CITY OF ALBUQUERQUE

June 26, 2019

**Re: Larry H. Miller Hyundai
Erosion and Sediment Control Plan
CPESC's Stamp Date 6-19-19 (B14E017)**

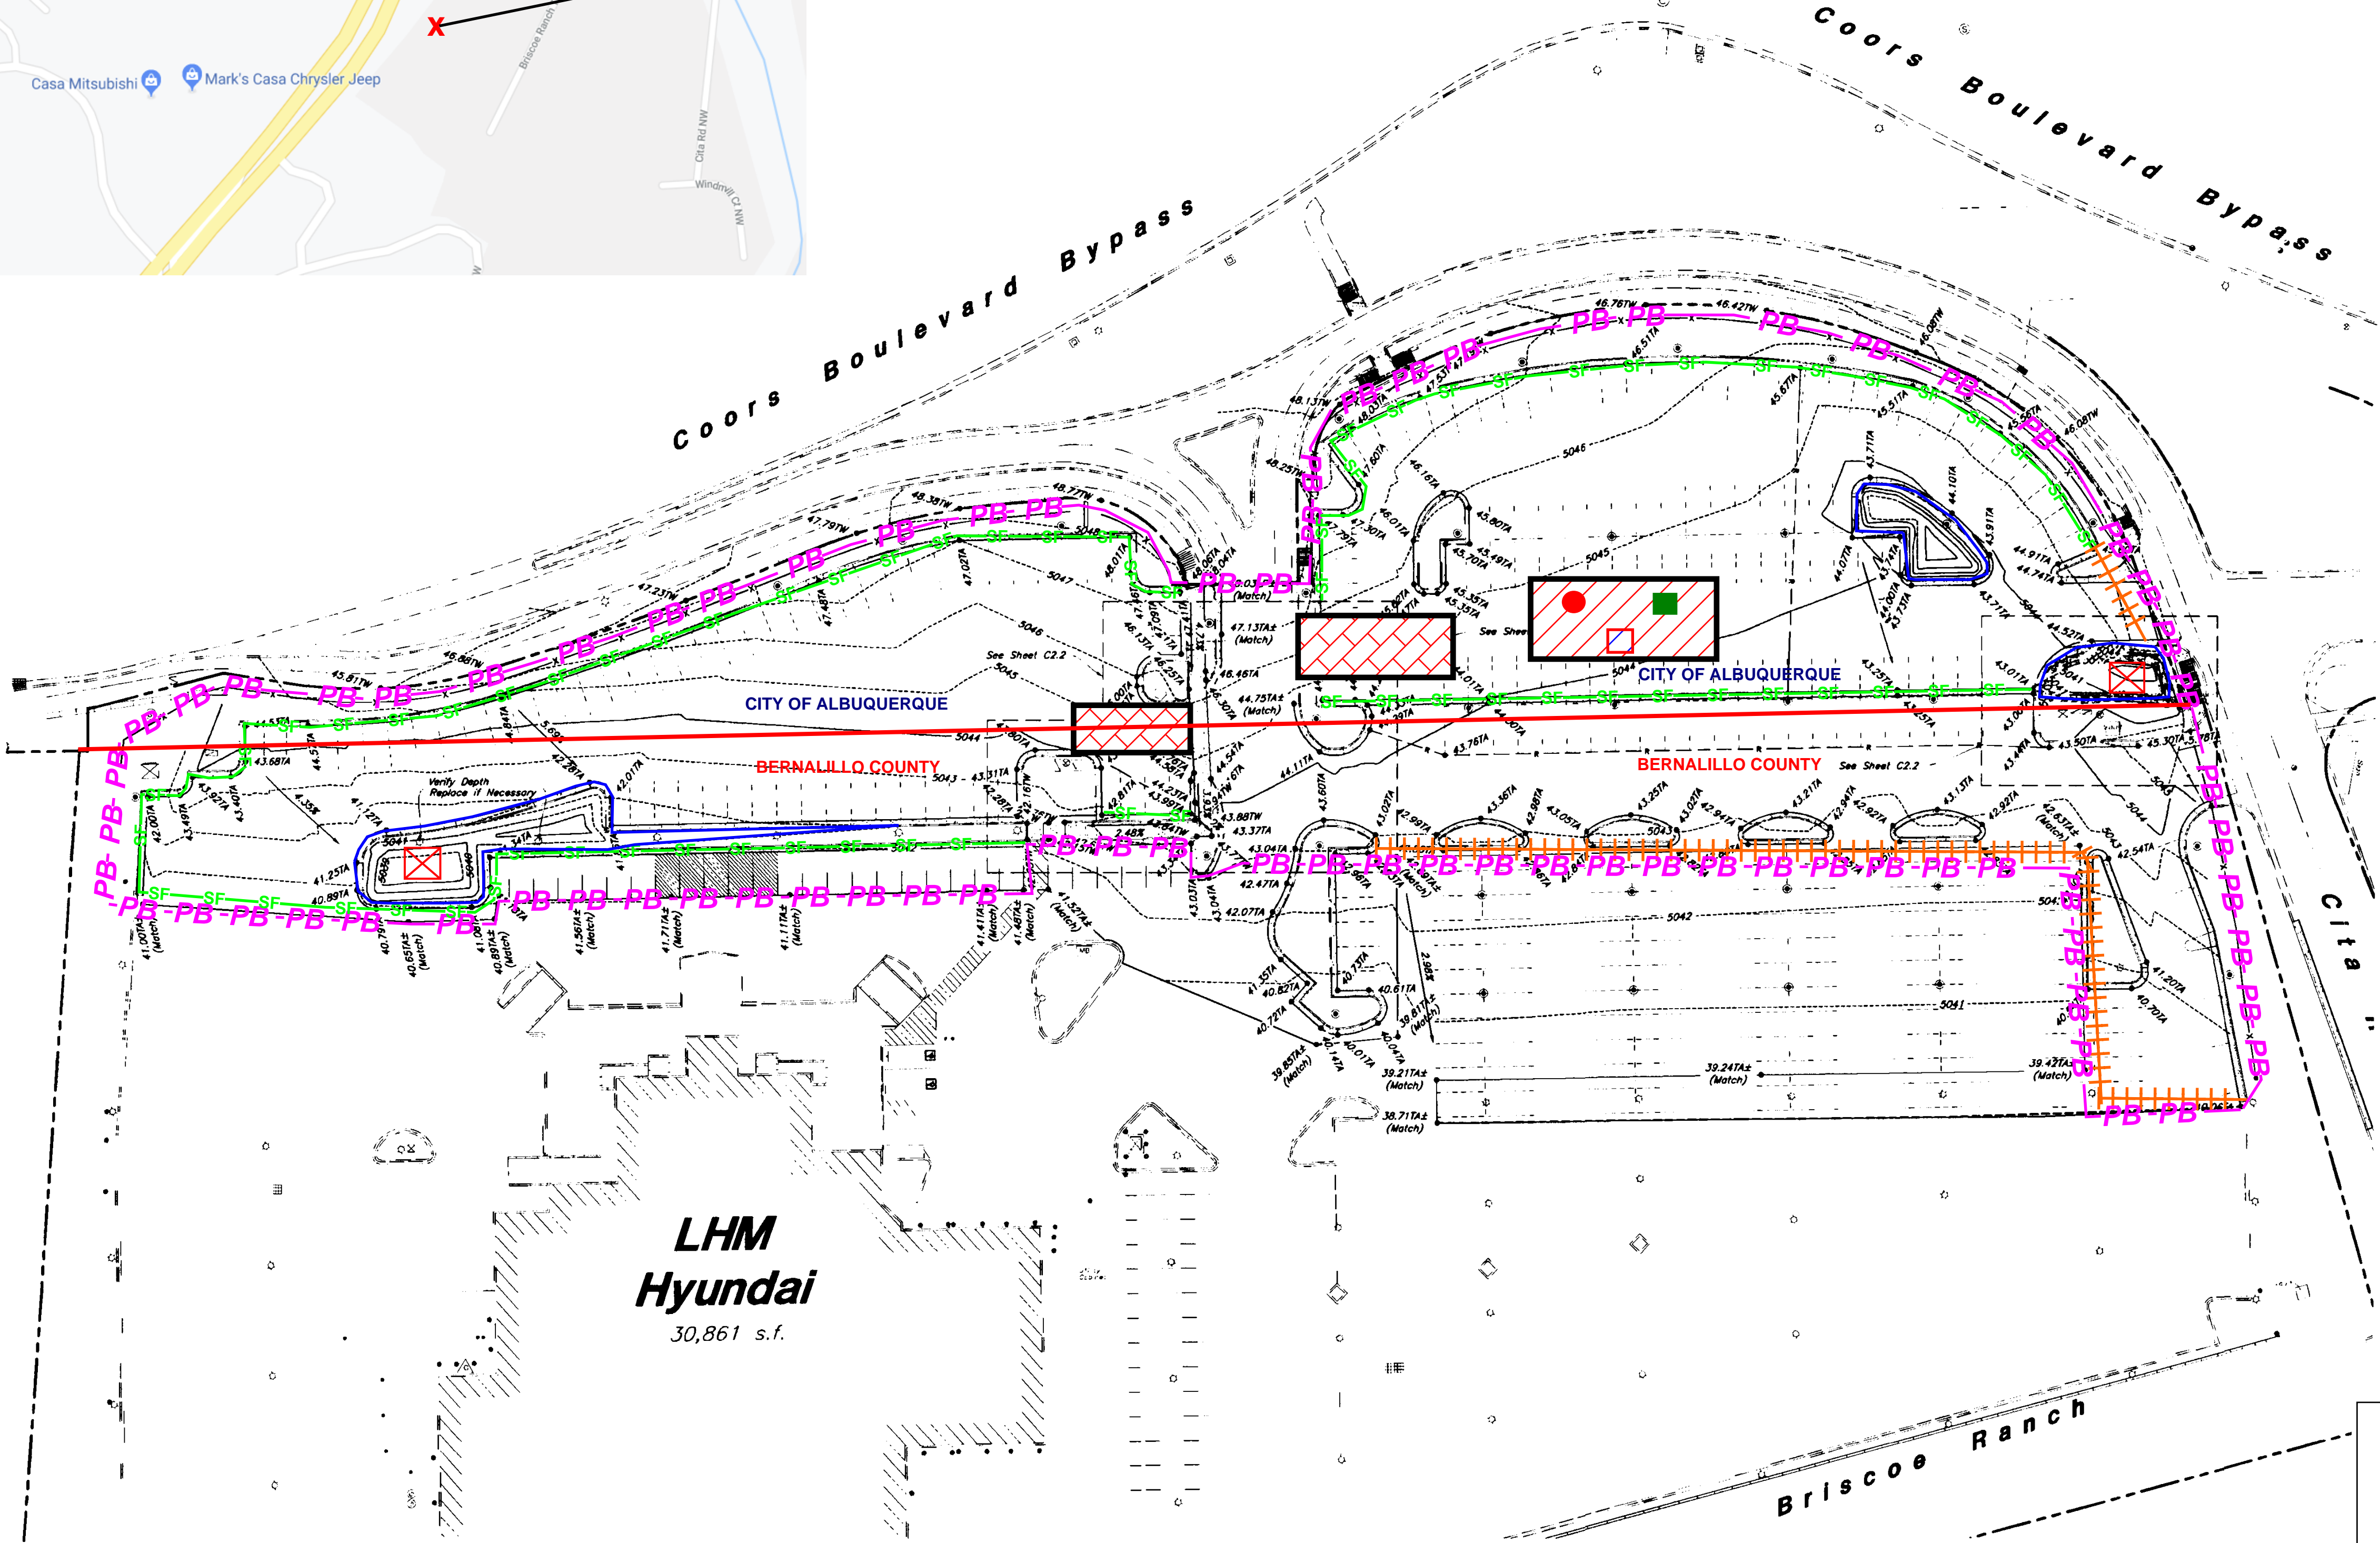
Since half of this site is in the City and the other half is not in the City, comments on the ESC plan will be limited to the portion of the site in the City limits.

1. Show the jurisdictional line on the plan.
2. Provide inlet protection for the proposed inlet in the northern pond.
3. Vehicle Tracking Control is not addressed on the plan.

The City is providing recommendations for BMPs outside the city limits. Since this portion of the site is outside City limits, these items are not required to be shown on the plan, but may help your client be in compliance.

1. Provide inlet protection for the proposed inlet in the southern pond.
2. Propose sediment BMP at the eastern edge of the disturbance.
